Our Case Number: ABP-309770-21

Re: Proposed development of up to 15 wind turbines with a tip height of up to 175 metres and laying of approximately 26km of underground electricity cabling to facilitate the connection to the national grid, and all associated site development works
Townlands of Camagh, Carlanstown, Coole, Clonrobert, Clonsura, Doon, Monktown, Mullagh, Newcastle and other townlands, Co. Westmeath

We wish to make a written submission on behalf of our party, Sinn Féin and local constituents in relation to the Planning Application by Coole Wind Farm SID (i) the upgrading, reorientation and expansion of an electricity substation in the townland of Camagh, Co. Westmeath. The proposed development of up to 15 turbines with a tip height of up to 175 metres in the townlands of Camagh, Carlanstown, Clonrobert, Clonsura, Doon, Monkstown, Mullagh, Newcastle and other townlands, Co. Westmeath; (ii) the installation of approximately 26km of underground cable between the proposed substation and the national grid at the existing Mullingar 110kV substation in Irishtown, County Westmeath; and (iii) associated site works and ancillary developments.

An Bord Pleanála Case reference: PA

Figure 7. Link 1 (Multyfarnham to Slieve Glah)

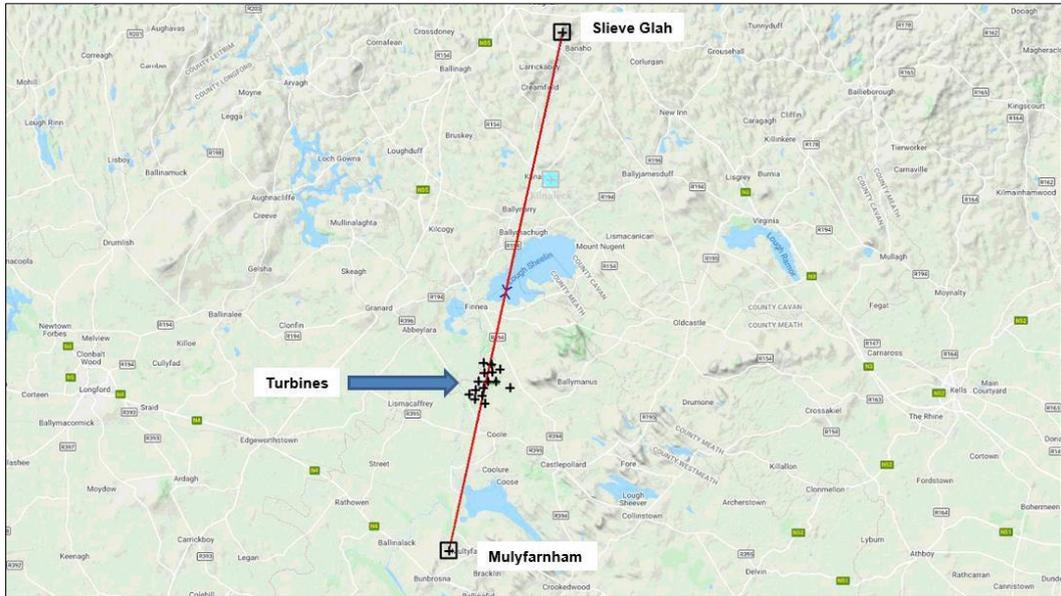
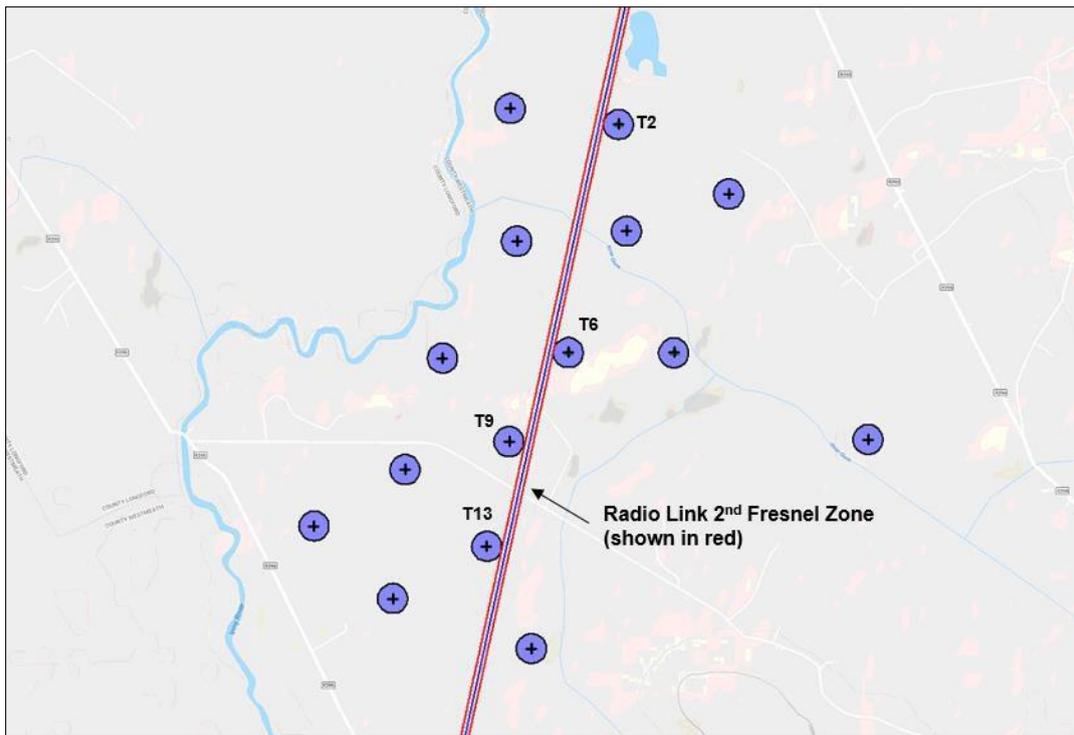
In fig. 3.2 it appears that turbines 2, 6, 9 and 13 are in the path of the buffer zone for Three Ireland. Three provides the only reasonable broadband coverage in this part of the county. Remote working will be impossible in this area if the currently fair internet coverage is degraded by blockage and disruption from the proposed turbines. This goes against proper planning and sustainable development for the area.
